CITY OF ALBUQUERQUE

March 26, 2025

RE: 845 Juan Tabo NE
Temporary Certificate of Occupancy
Engineer's Certification Date: 3/15/2025
Engineer's Stamp Date: 10/09/2024
Hydrology File: K21D019
Case # HYDR-2025-00091

845 JUAN TABO BLVD., NE GRADING AND DRAINAGE PLAN

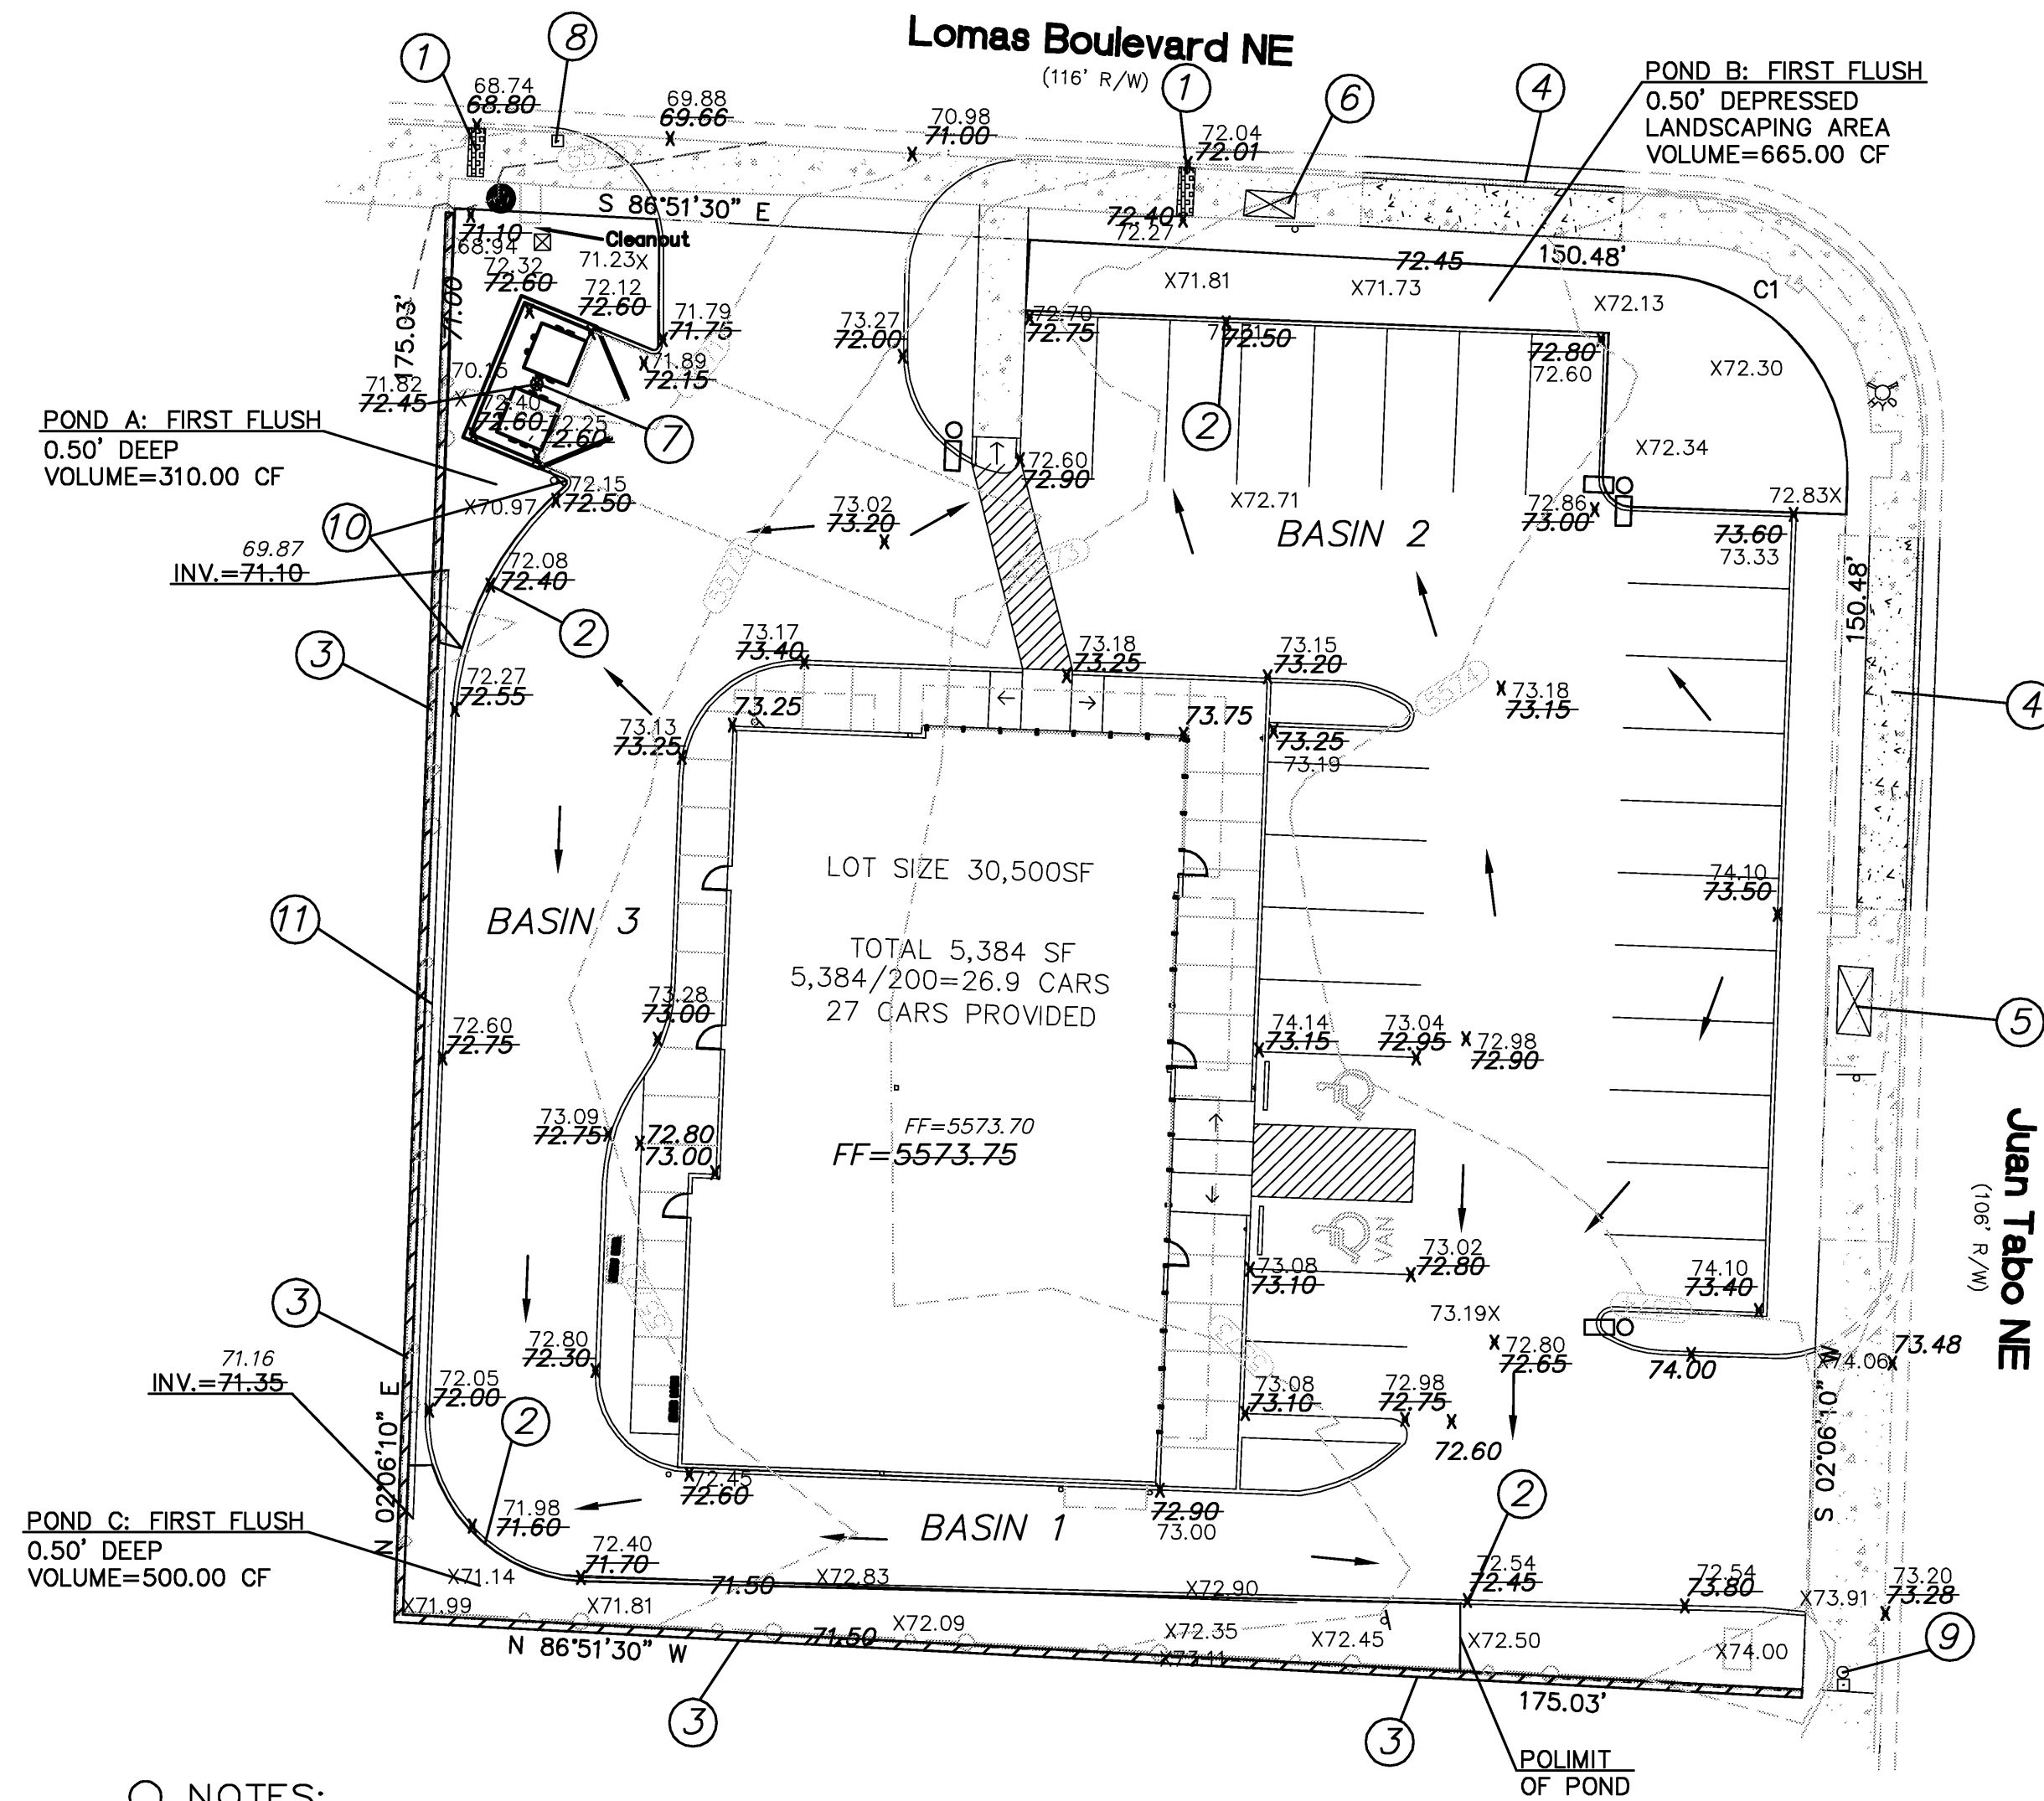
1. Please provide the Drainage Covenant with Exhibit A for the stormwater quality ponds per Article 6-15(C) of the DPM prior to Permanent Release of Occupancy. Please submit the original copies along with the **\$ 25.00** recording fee check made payable to Bernalillo County to Hydrology. Apply for a Covenant in the ABQ-PLAN system. Upload the Drainage Covenant and Exhibit A as attachments.
2. Complete the construction of the sidewalk culvert at the NW corner of the site.
